## Department of Planning and Environment

**Subject:** Upper South Creek Advanced Water Recycling Centre (SSI-8609189) Response to Submissions Report

### Attachment A – EHG comments on Upper South Creek Advanced Water Recycling Centre RtS Report

**Figure 4-10 WorleyParsons (2015) and AWRC study 1% AEP flood extents using ARR 1987 Guidelines**

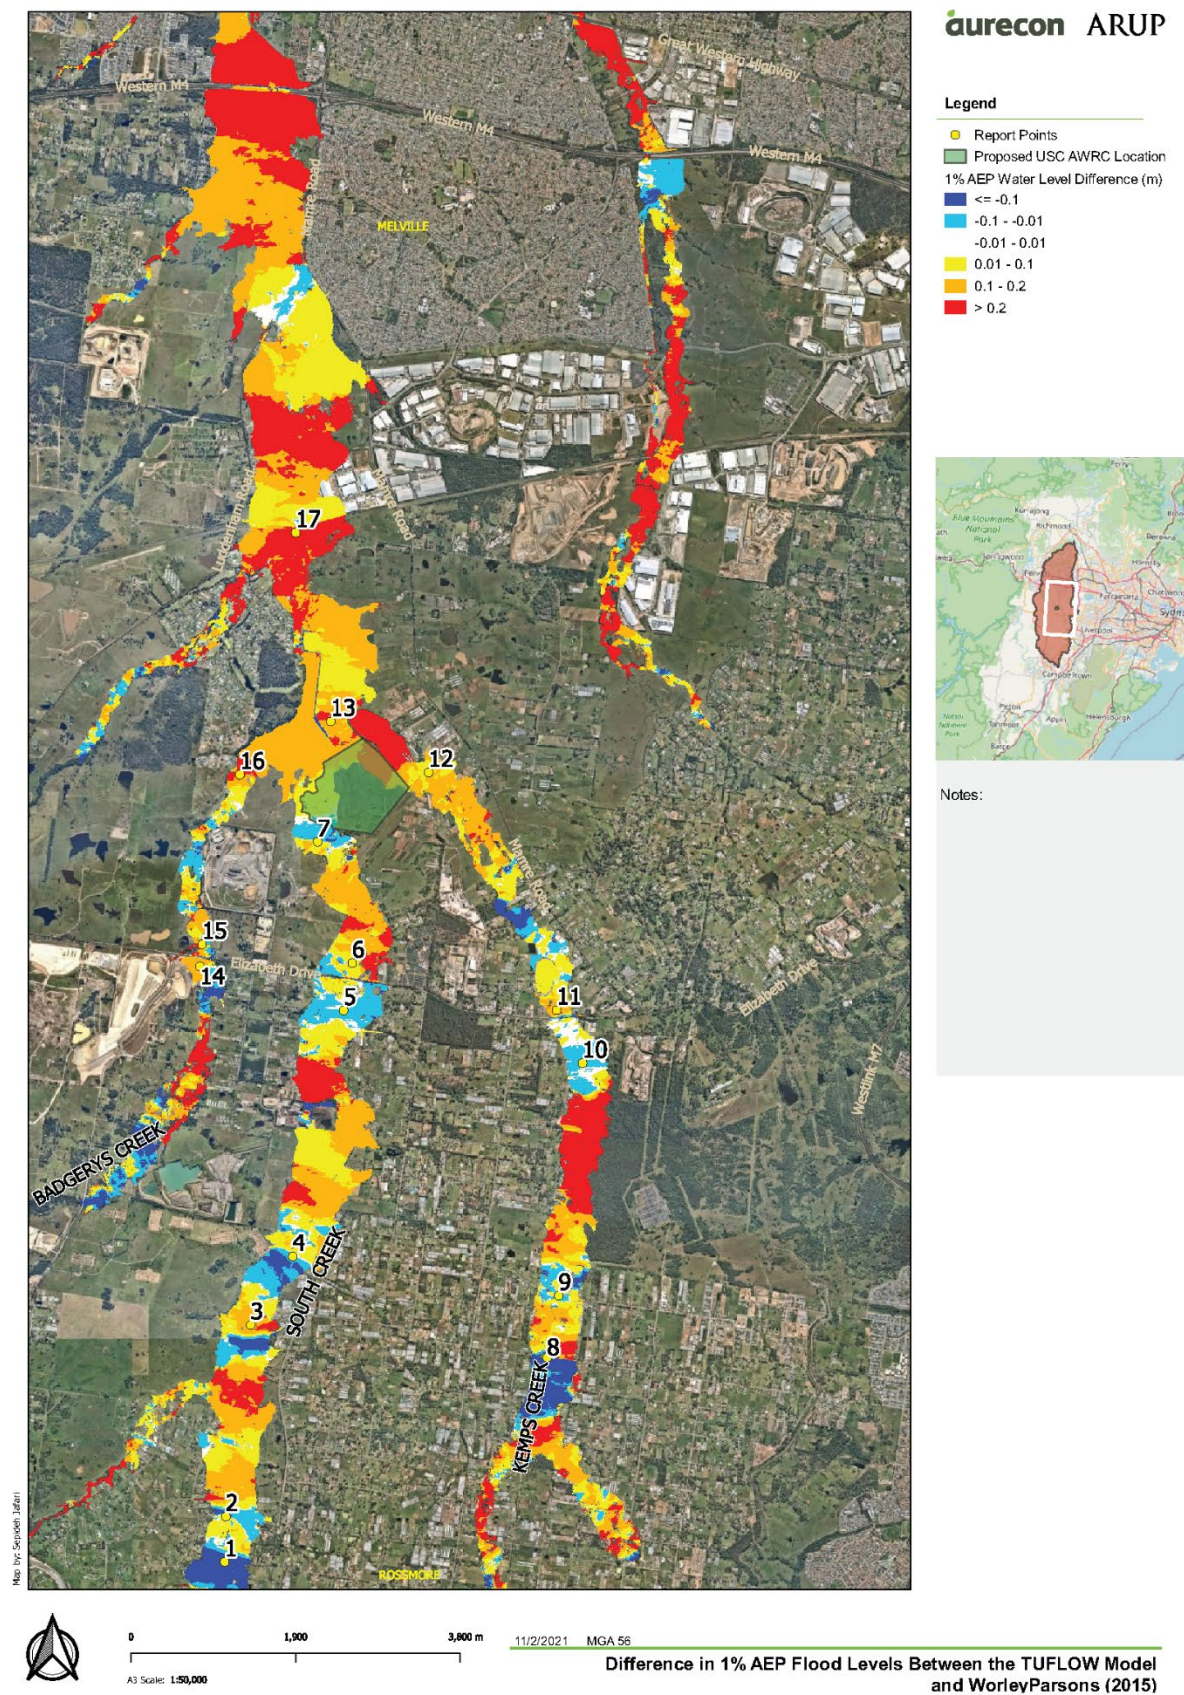
EHG has previously addressed the inconsistency between the Aurecon ARUP flood assessment 2021 results and Penrith's WorleyParsons (2015) results. In addition, the figures below highlight the inconsistency between Aurecon ARUP flood assessment 2021 results and INSW 2020 results.

The figures above show significant inconsistency in flood behaviour results by Aurecon ARUP flood assessment 2021 (bottom figure) comparing to Council's 2015 results (upper left figure) and INSW flood assessment (upper right figure).
